## Application for a Non-Material Amendment Following a Grant of Planning Permission

demolition of the existing dwelling and erection of a two storey plus lower ground floor level detached dwellinghouse with integral garage, associated refuse/recycling store, cycle store, amenity space and provision of 2no.off street parking spaces

22/0501/ful

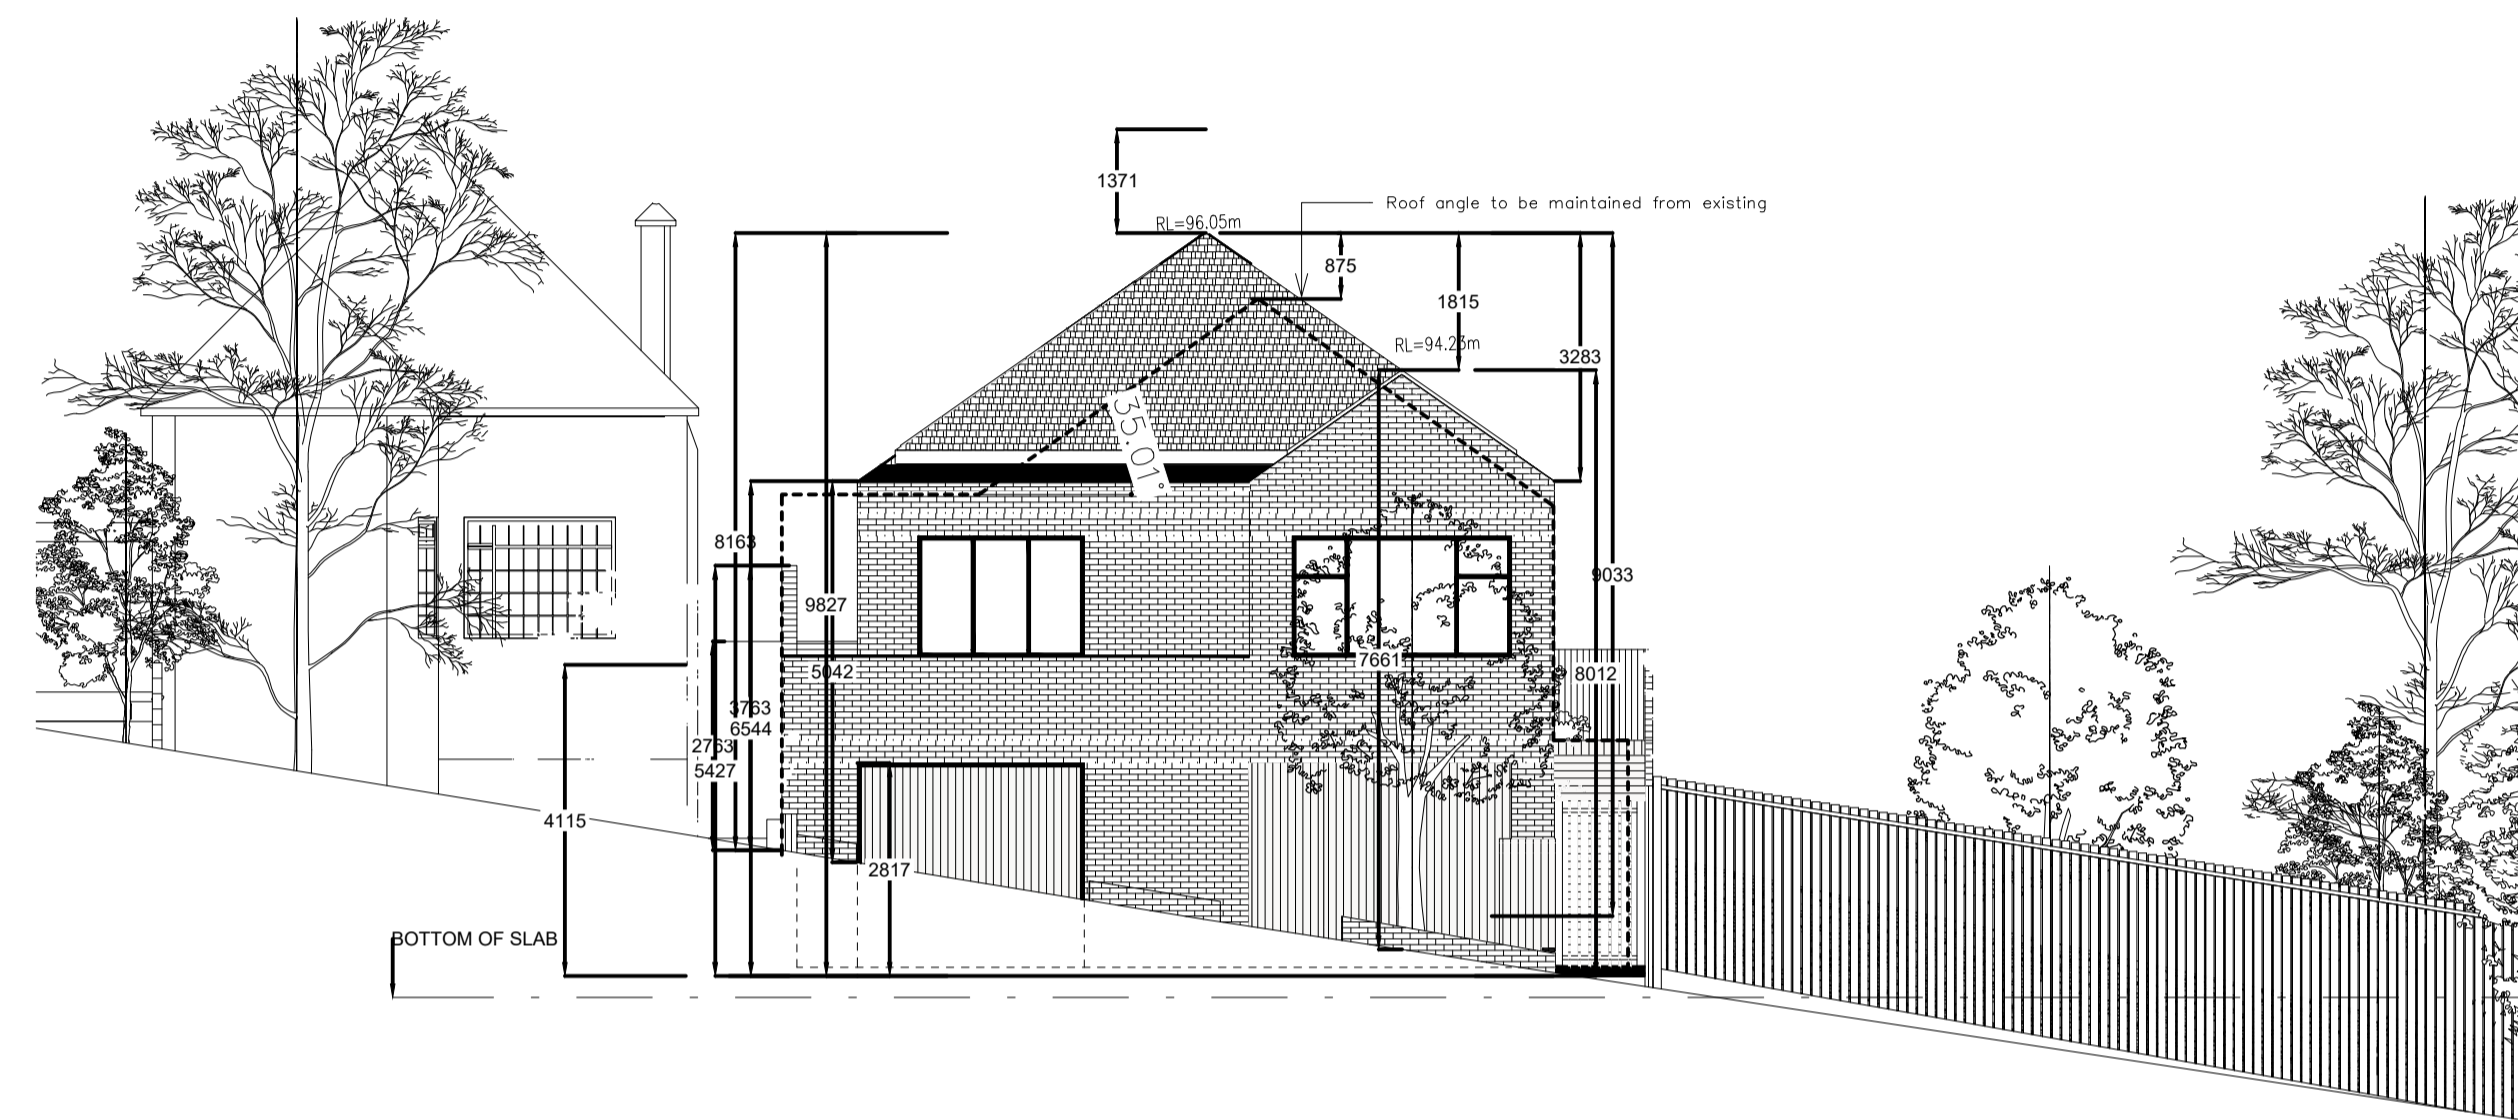
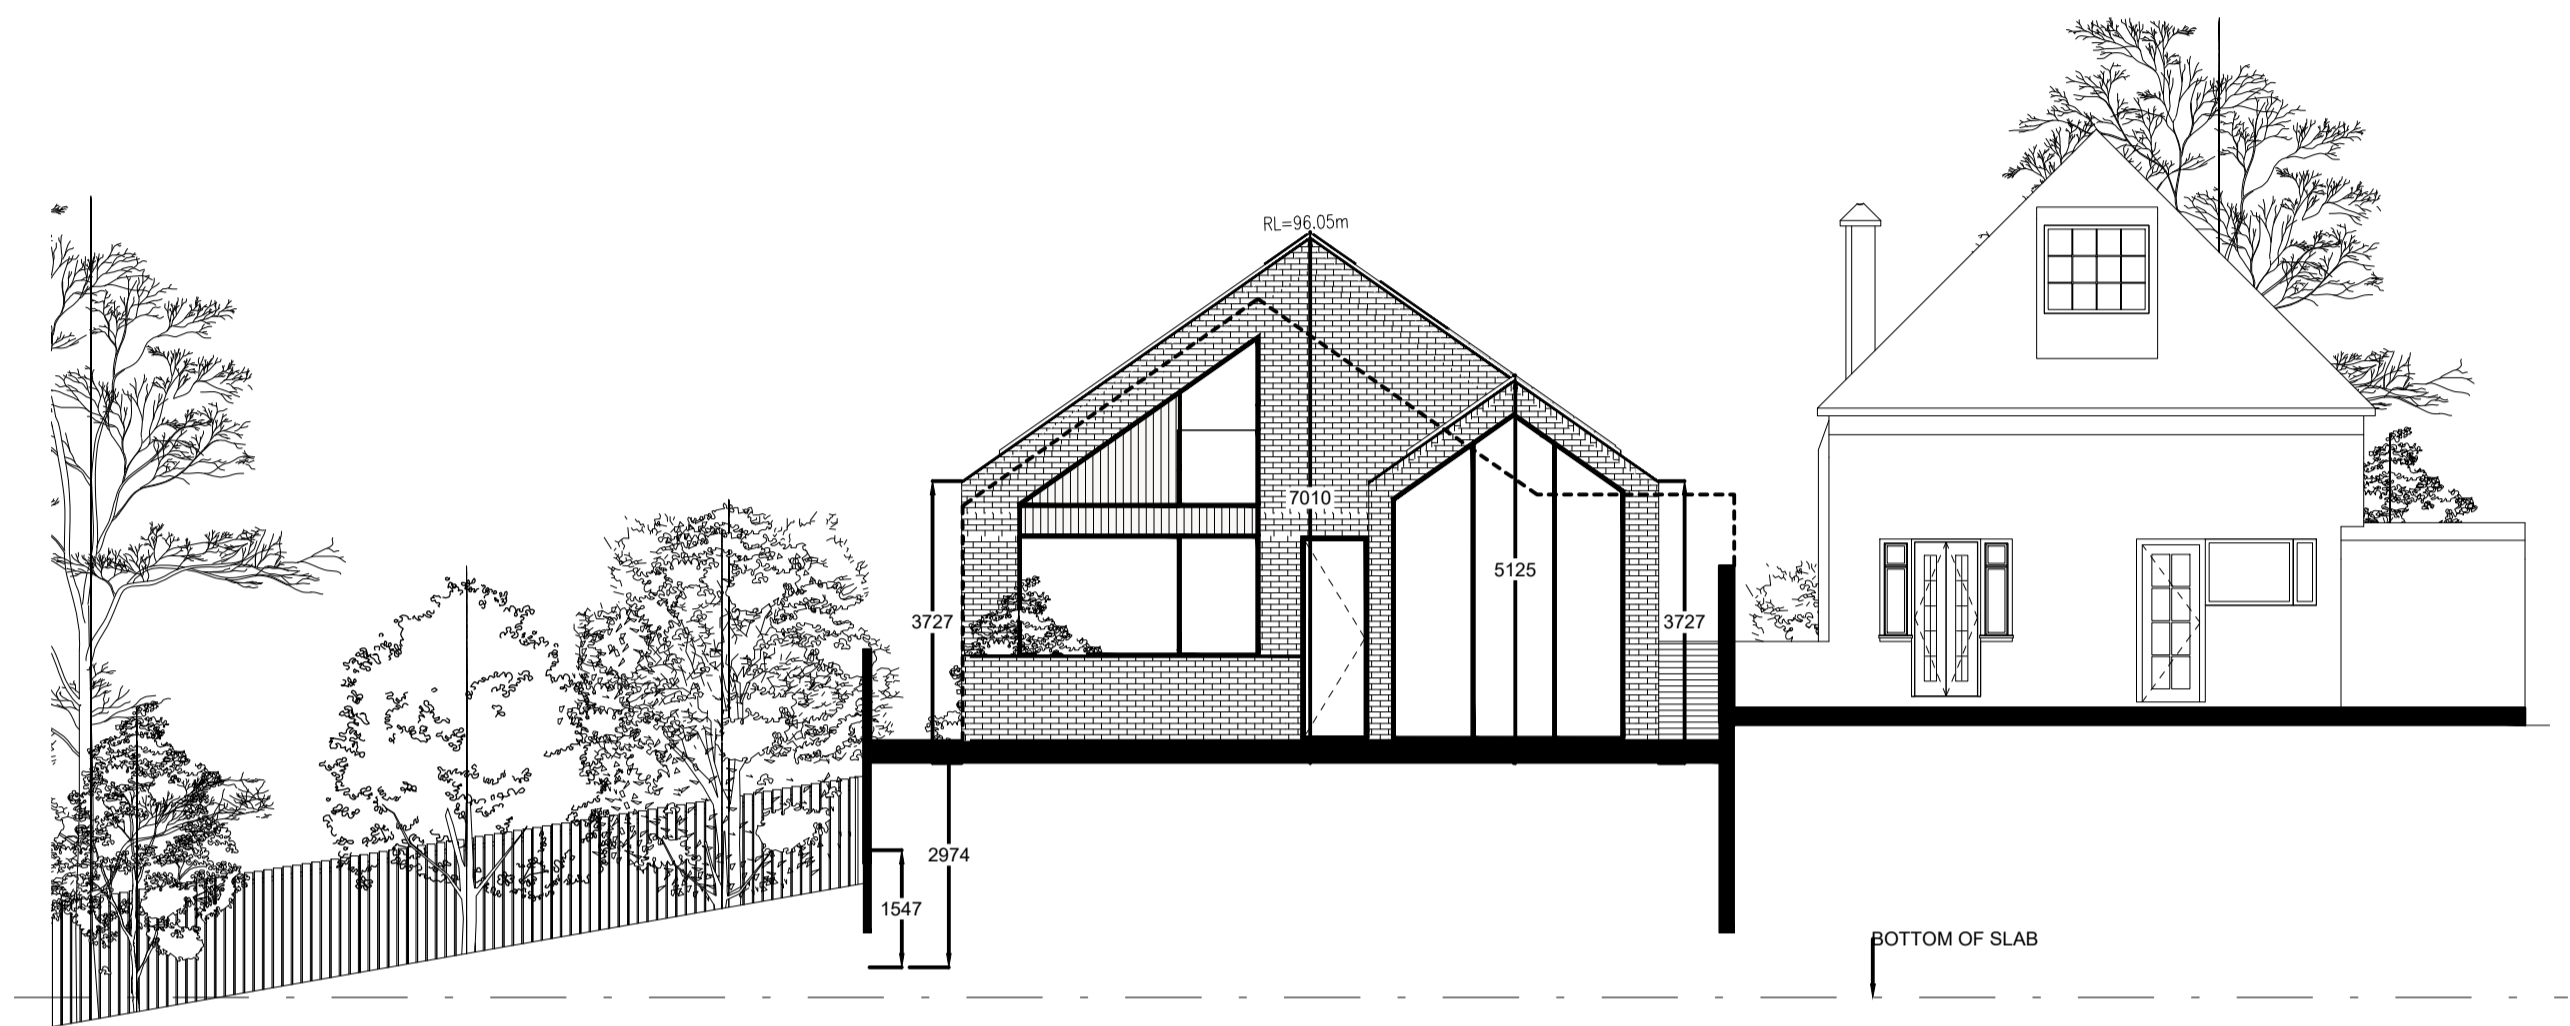
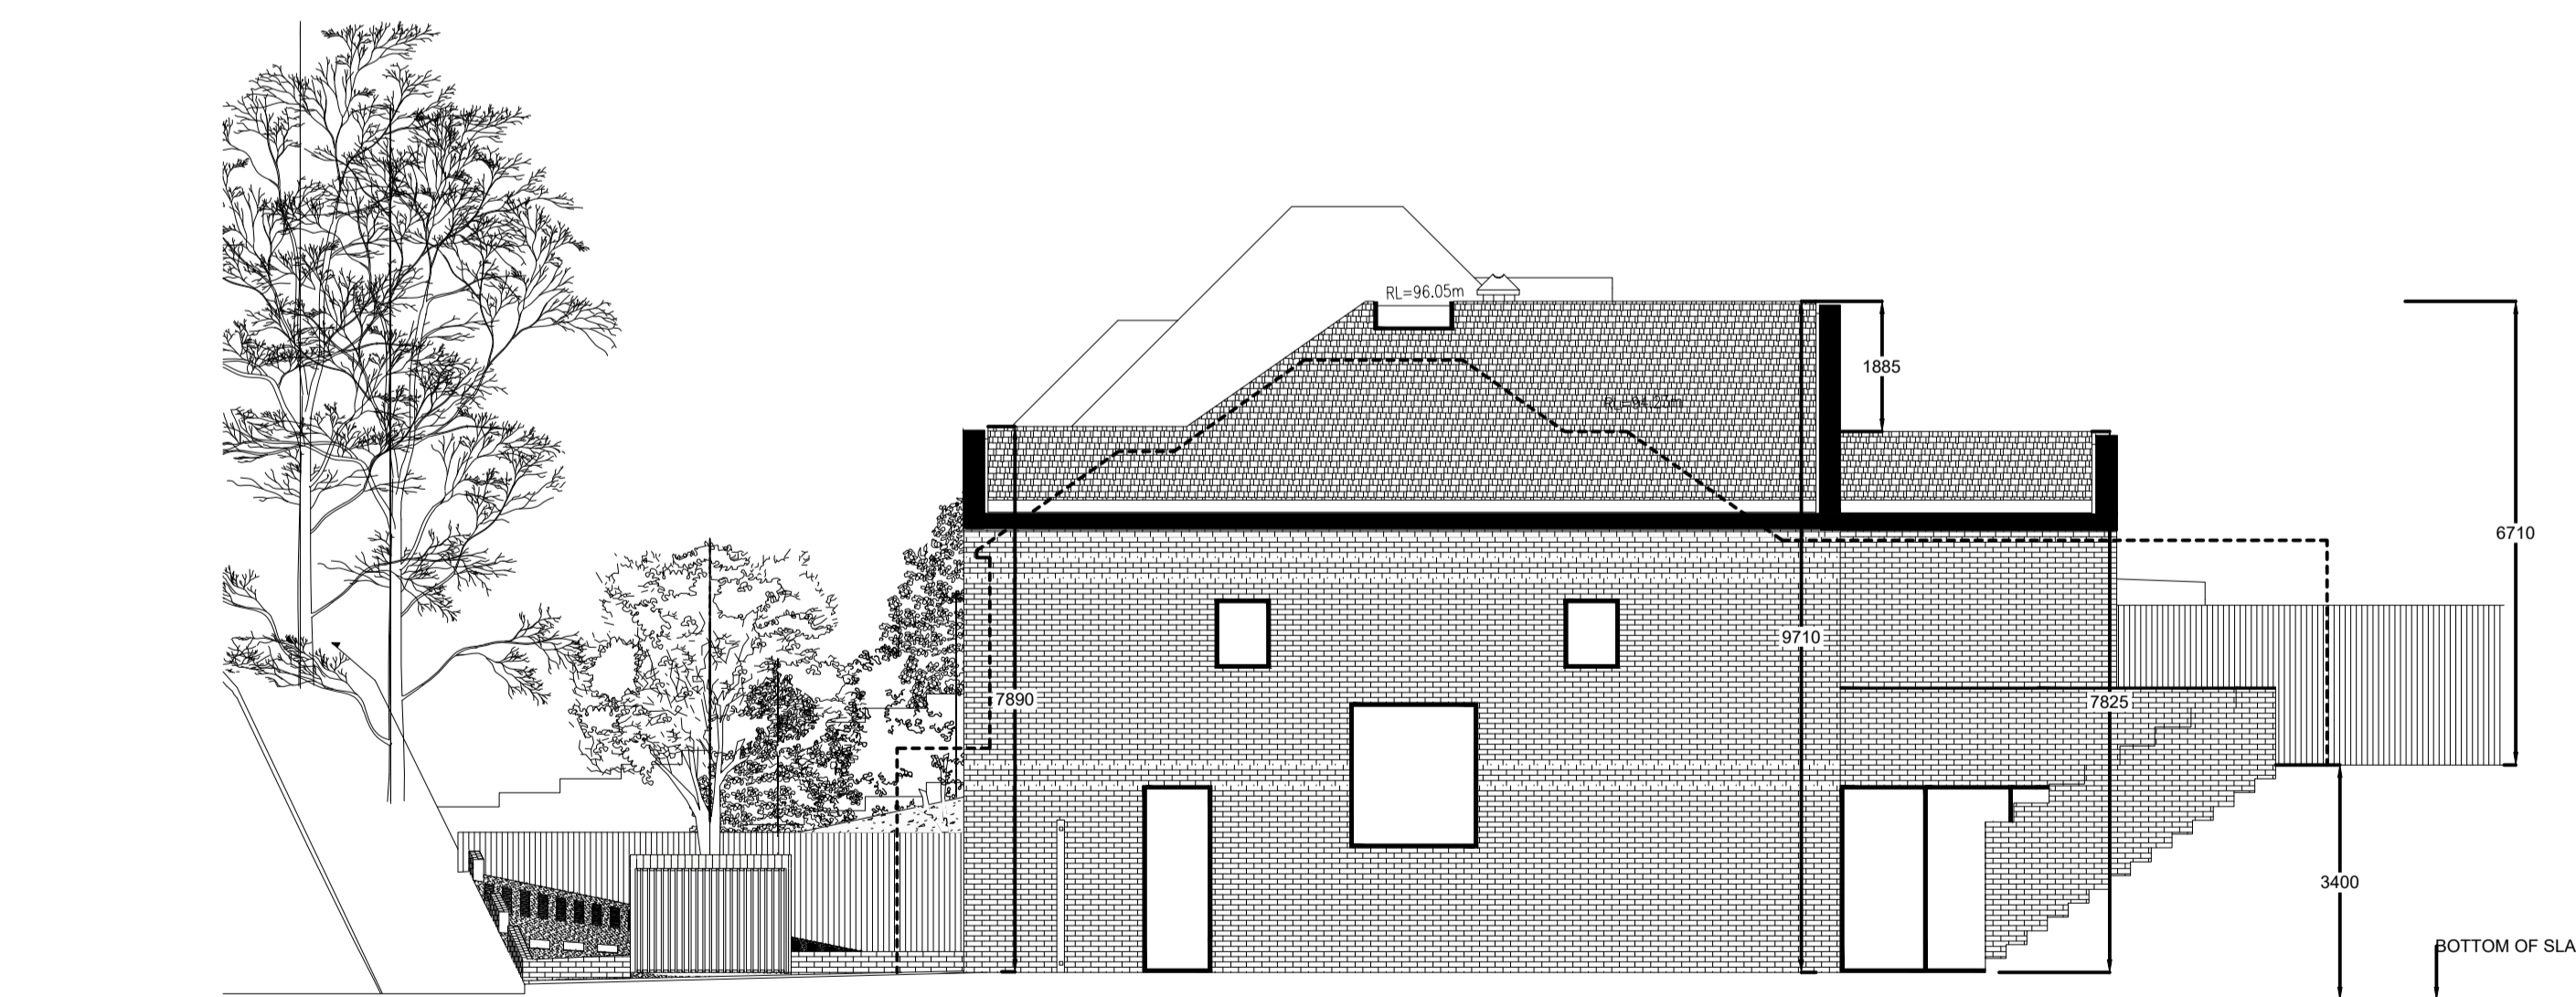
the back addition part of the build has been extended by 500mm

to rectify the build
